CITY OF PORTLAND, MAINE

January 28th, 2013

Project Name: **Mixed Use Development at 321 Commercial Street (corner Maple Street)**
Project ID: 2012-615 CBL: 40-E-3
Address: 321 Commercial Street
Applicant: J B Brown & Sons
Planner: Jean Fraser

SITE PLAN

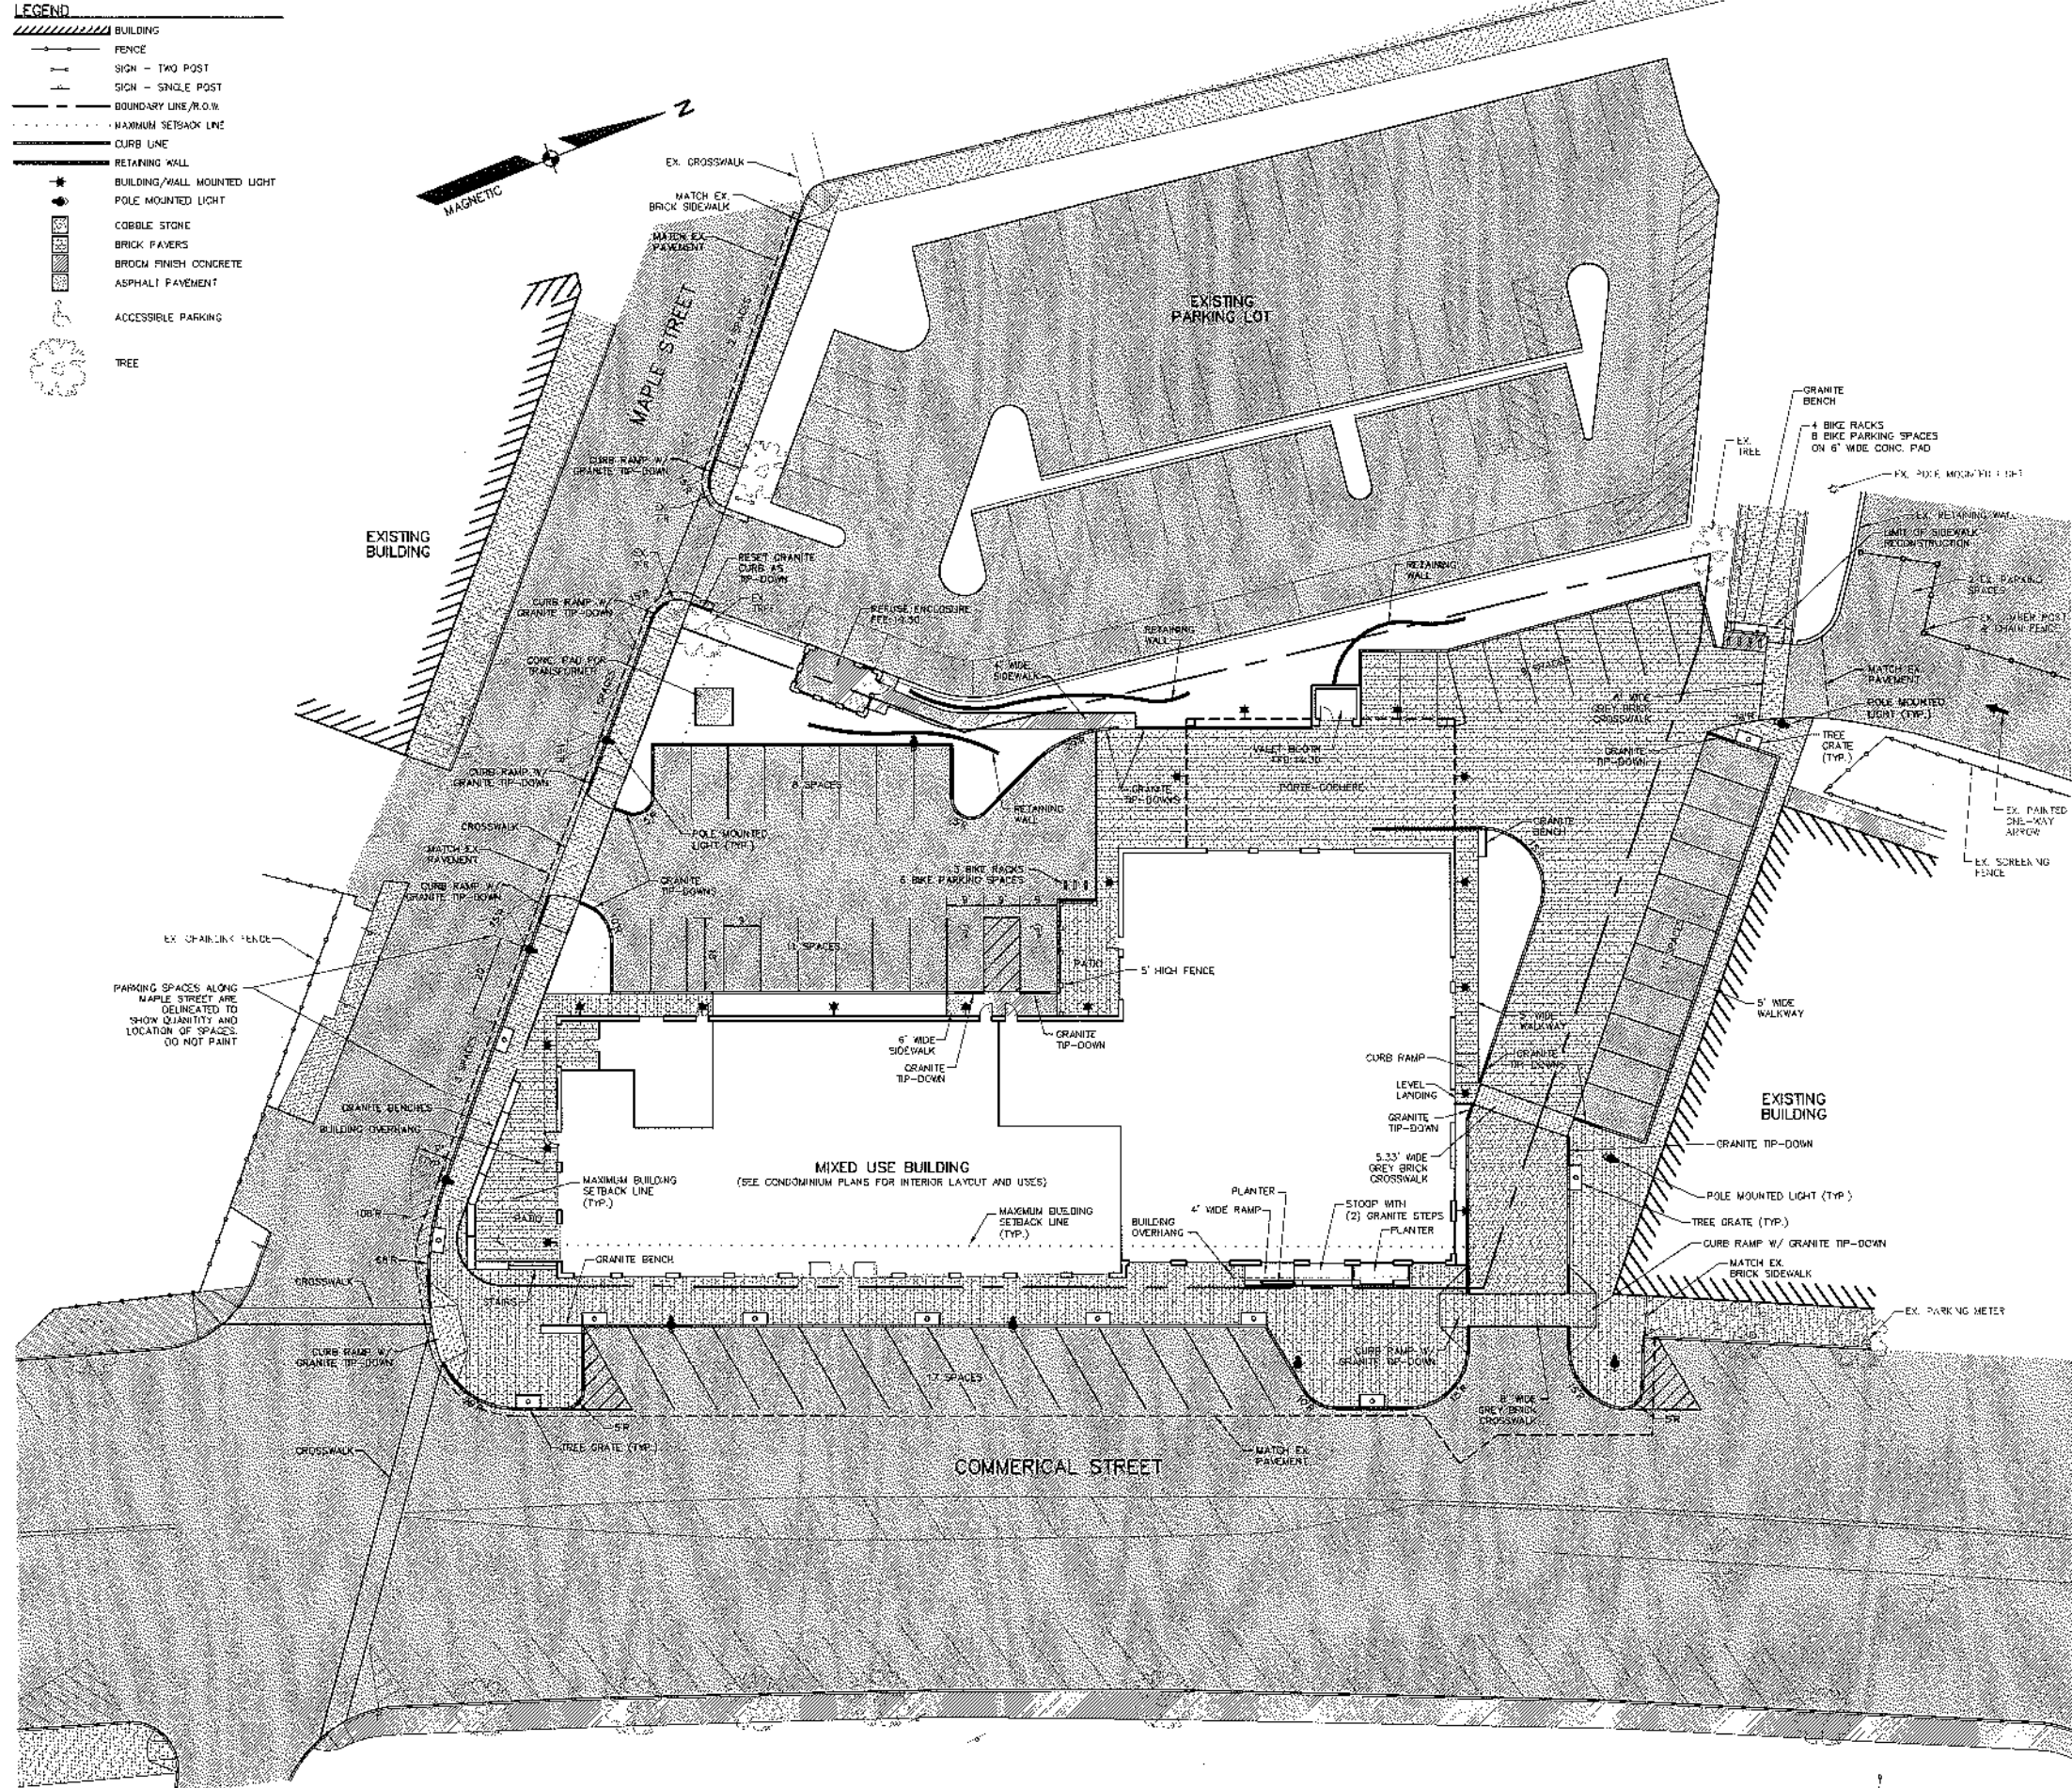
The Planning Board waives Technical Standard, Section 1.20.1, to allow a reduction in the required sight distance to the centerline of the crosswalk on the east side of Commercial Street, subject to the removal of the parking space nearest to the crosswalk.

- o The Commercial Street crosswalk shall not intersect the Maple Street crosswalk at an "apex" location. Separate crosswalk ramps shall be constructed on the project site corner. This change may require some adjustment to the proposed stormwater planter.**

- o **For improved safety it is suggested that an additional parking space be eliminated on Commercial Street abutting the proposed crosswalk. Accordingly, the striped island will need to be expanded.**
- o **The applicant shall install crosswalk warning signs that meet standards in the MUTCD.**

* November 9, 2012 Comment: I need to review the design details on the diagonal parking on Commercial Street (e.g. dimensions, painted corner areas, etc.).

December 12, 2012 Comment: The dimension of the diagonal parking spaces are not consistent with existing diagonal parking spaces located on Commercial Street. The spaces seem to be longer. I'll need to coordinate with DPS staff.

Status: It is suggested (not recommended) that the parking space dimensions match those of other parking spaces on Commercial Street. I'm comfortable if the parking space dimensions remain unchanged if the alignment of the westbound travel lane on Commercial Street is not off-set or requires vehicles to shift.

STORMWATER PLANTER PLAN
NOT TO SCALE

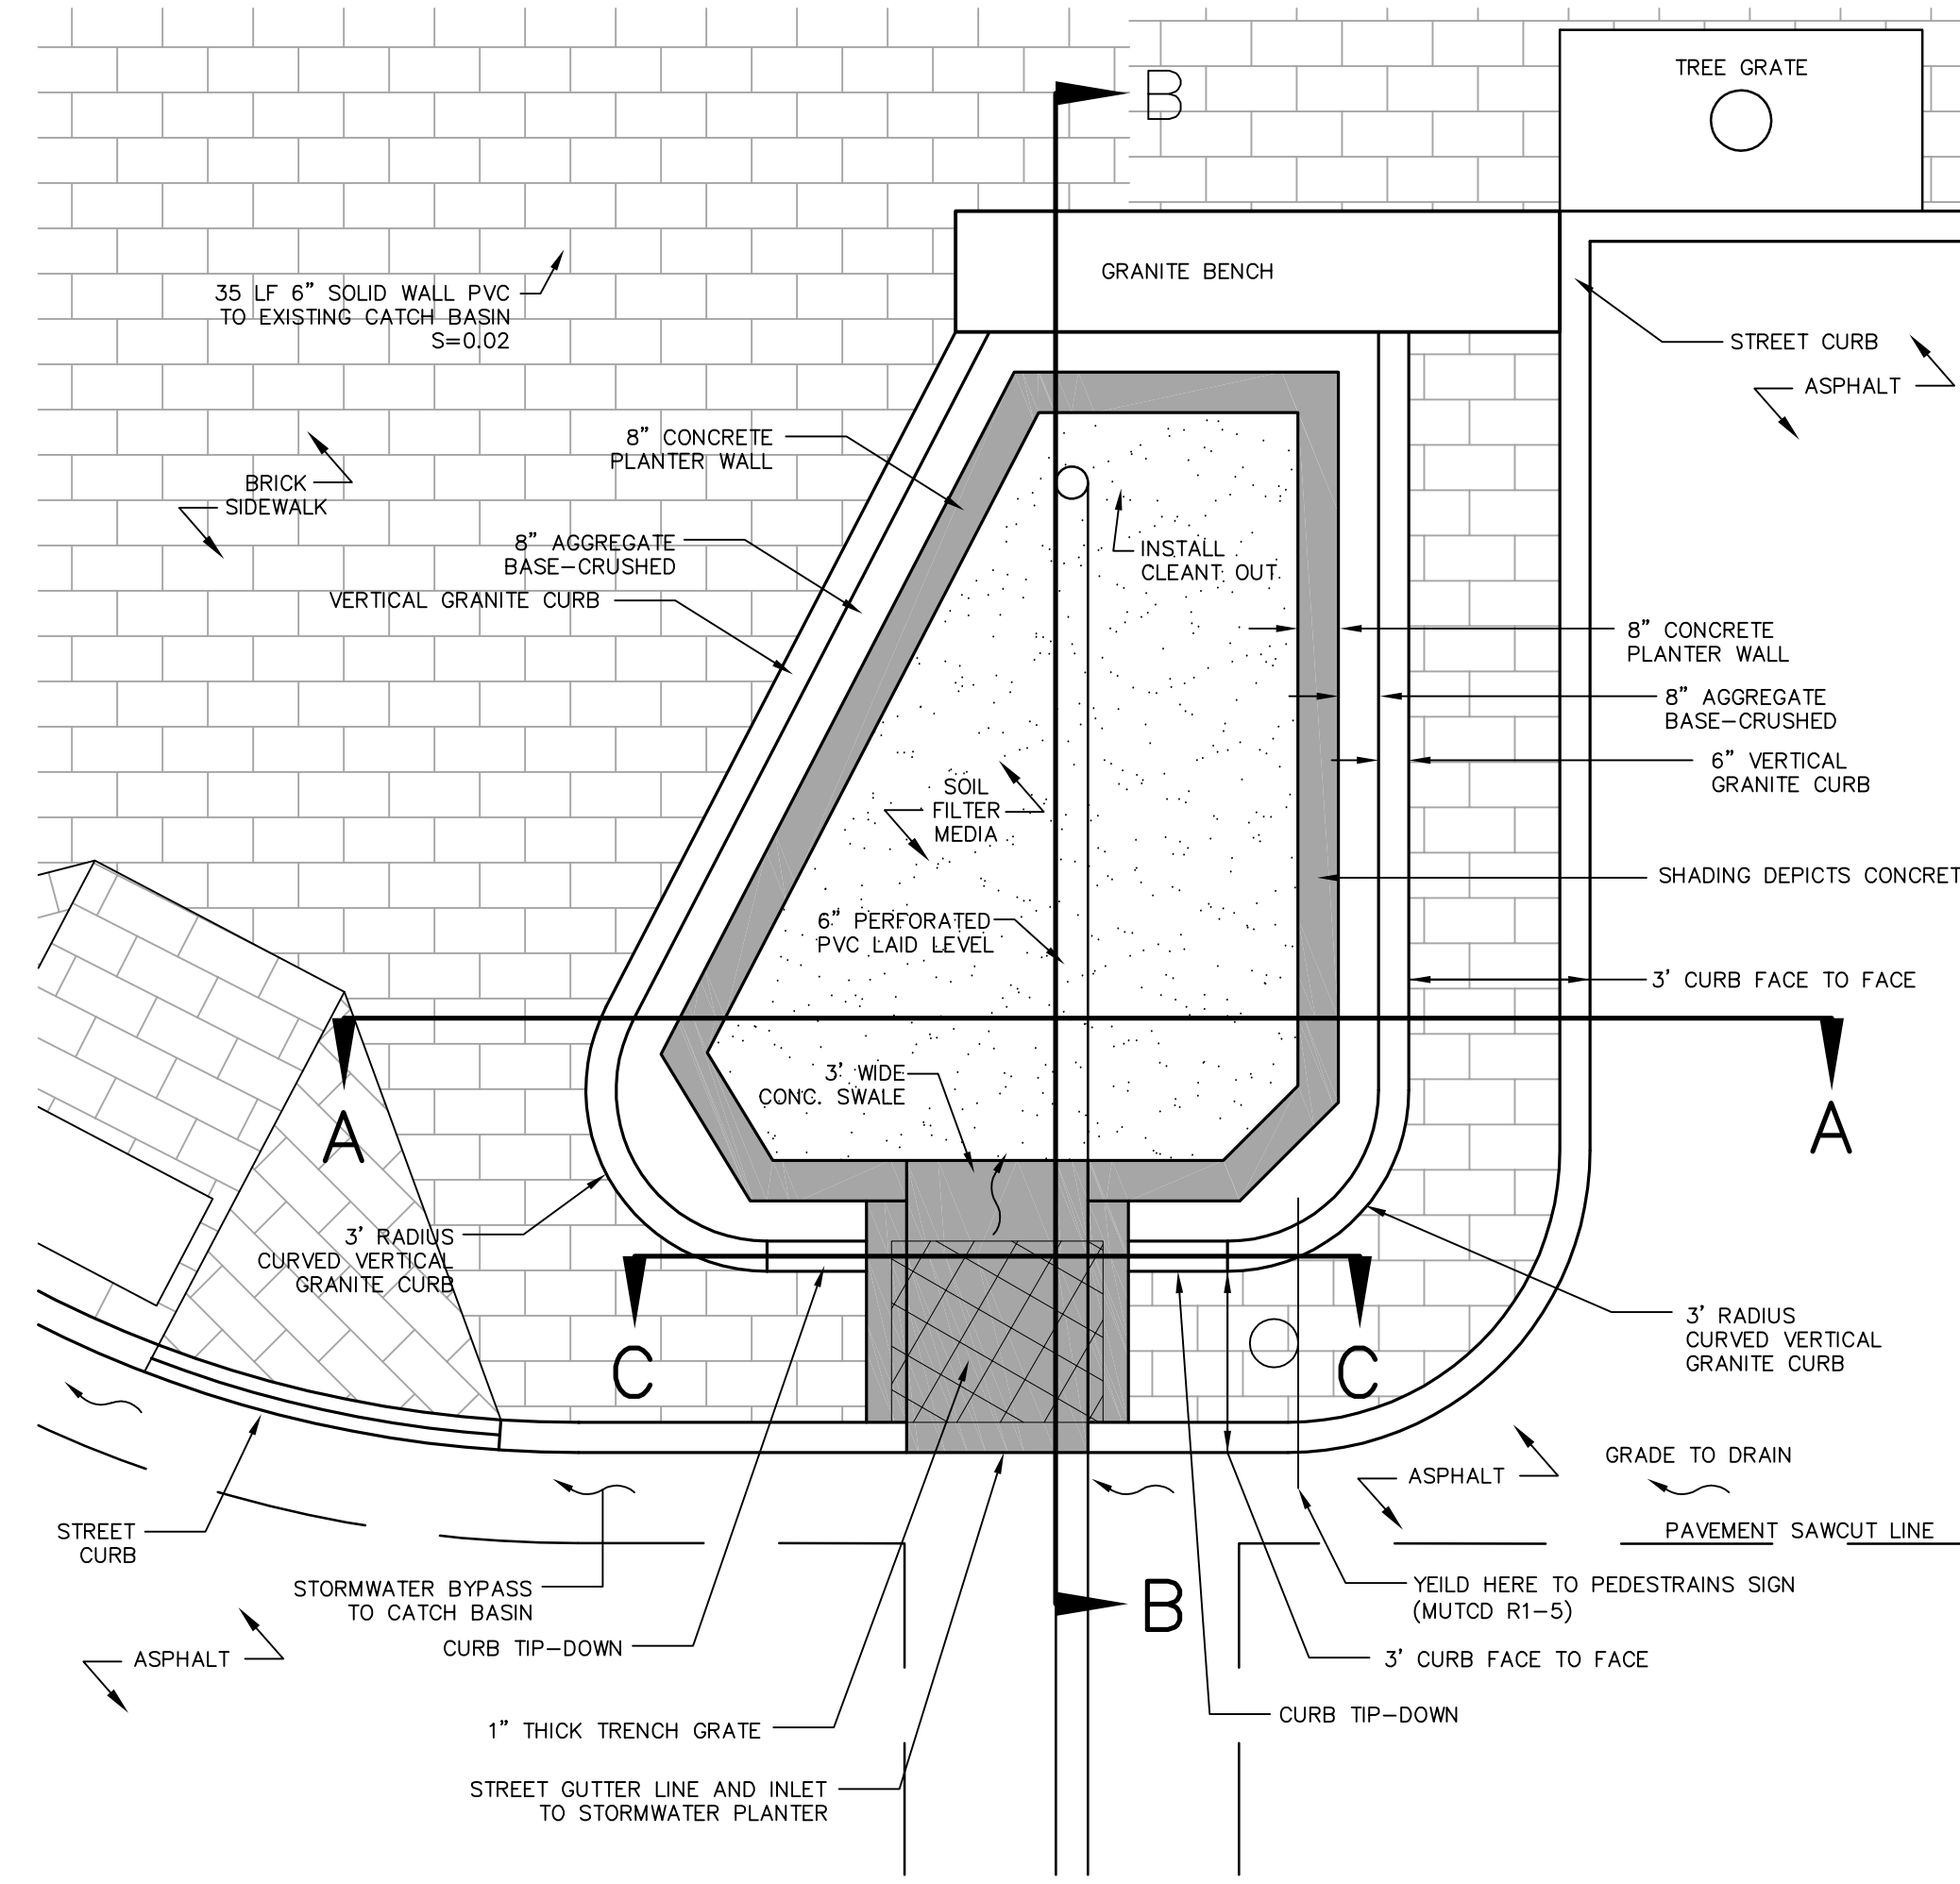
8. That the Stormwater Planter underdrains shall not be tied into the existing catch basin in Maple Street, but shall be directly connected to the City's 18inch RCP stormdrain in Commercial Street via an insert-tee connection; and
